5th March 2021

Application No: BE/17/21/HH
Site Address: Liseve Lodge 84 North Bersted Street Bersted PO22 9AQ
Description of works: Removal of car port with replacement single storey orangery extension, proposed two storey side extension with further living room extension.

Thank you for your internet representation made on 4th March 2021 which has been recorded as an objection with the comments as follows:

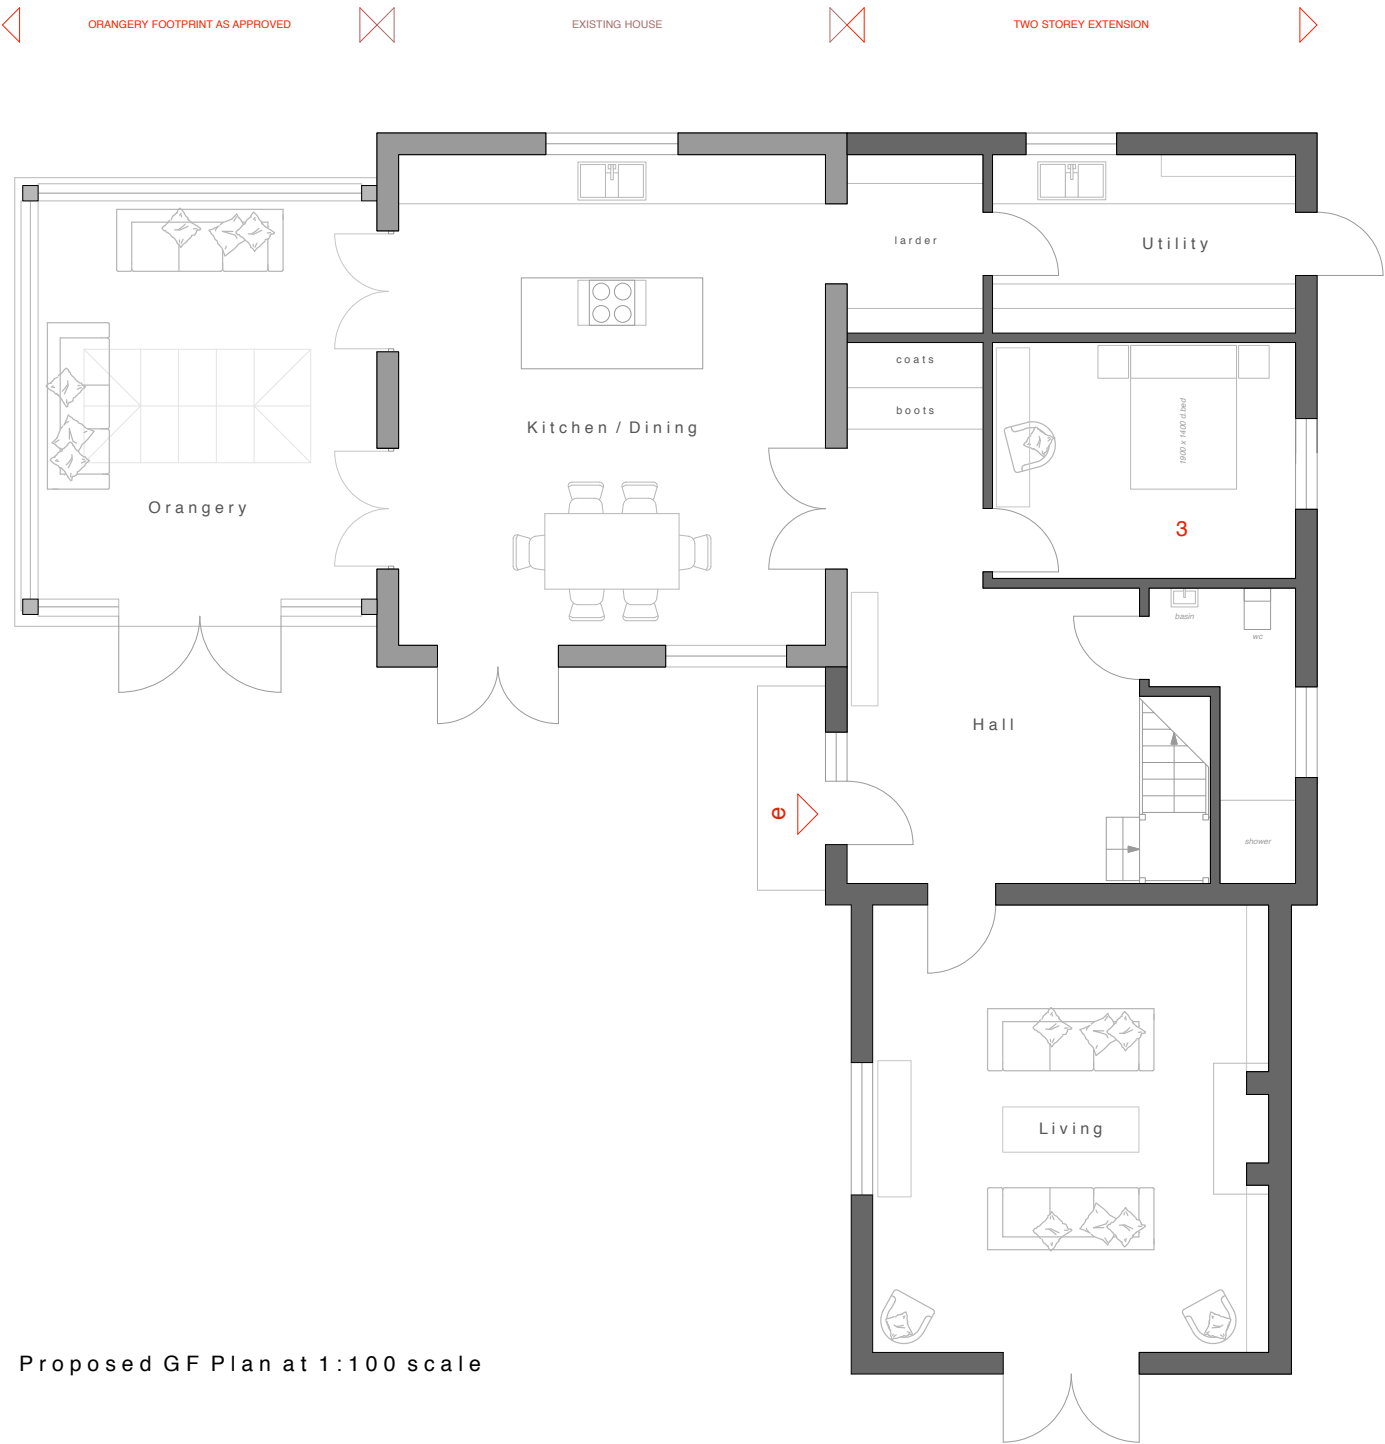
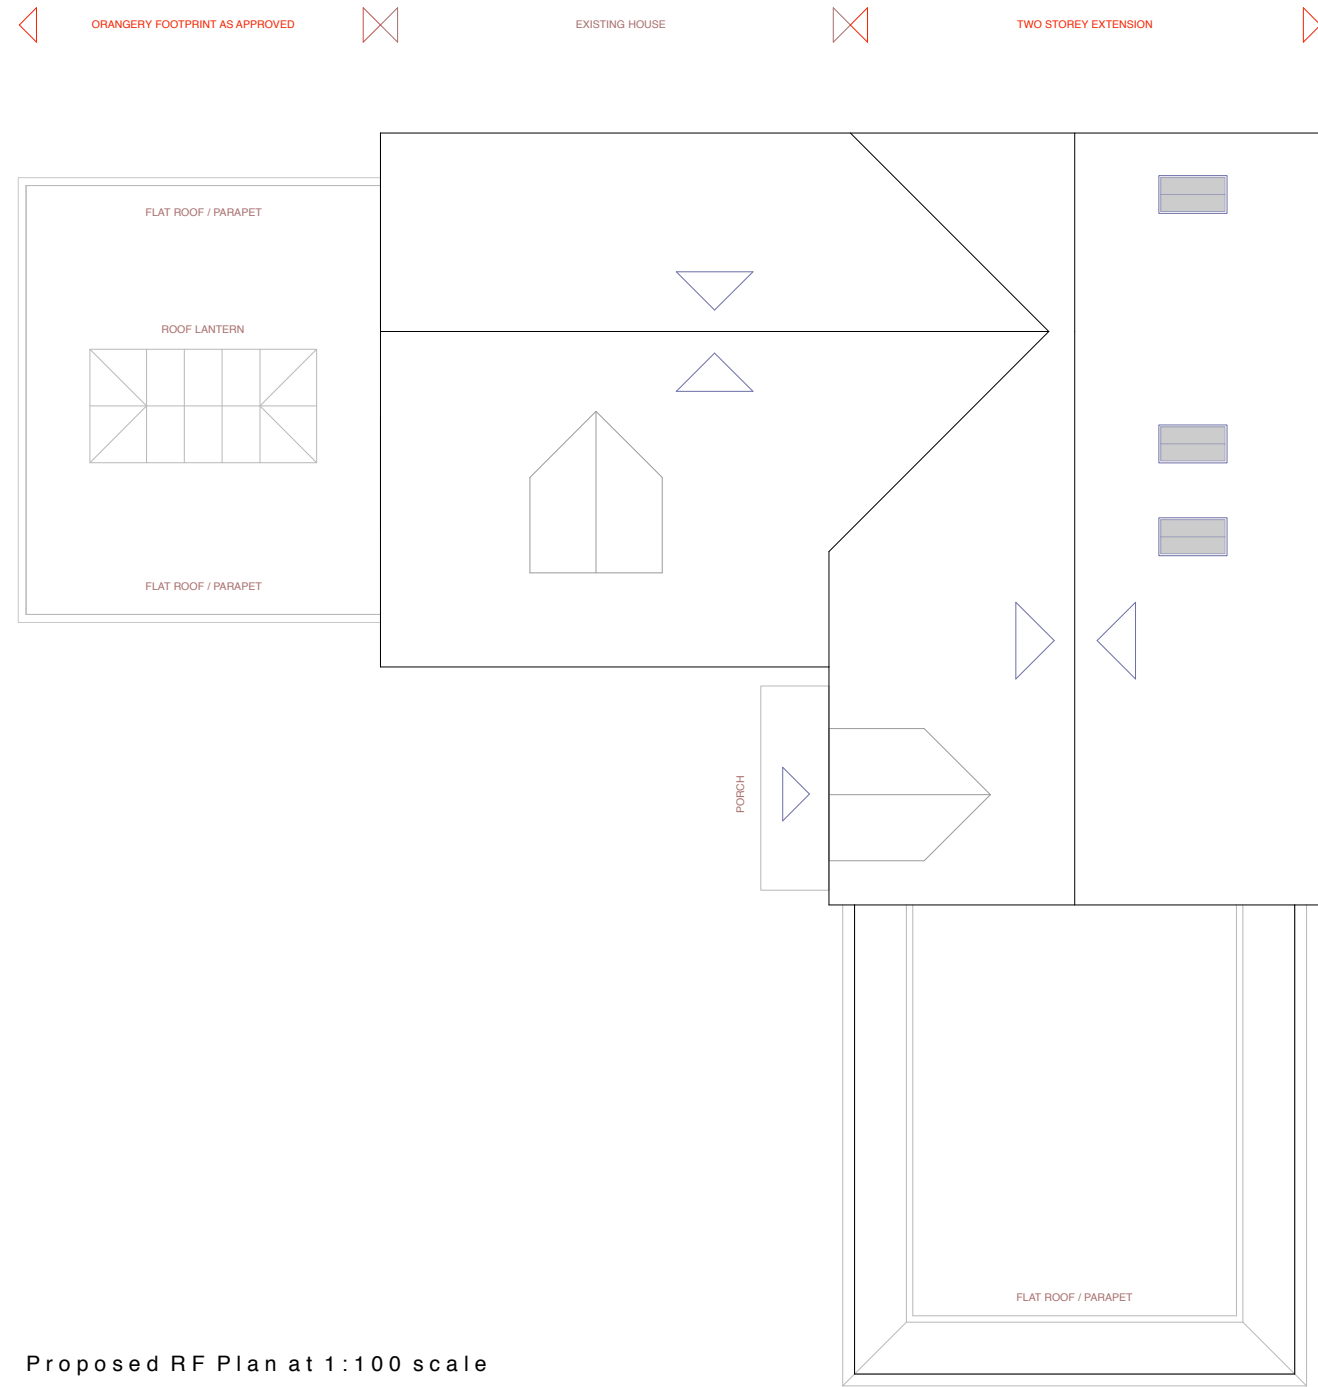
- 1) The site is considered an overdevelopment and is contrary to Local Plan Policy D DM4 extensions and alterations. The footprint of the proposed extensions appears to be over 50% of the original building.
- 2) Flood Risk as the Environment Agency class this as being in Zone 1.
- 3) The application falls in the North Bersted Conservation Area and the proposed extensions would not enhance this area.
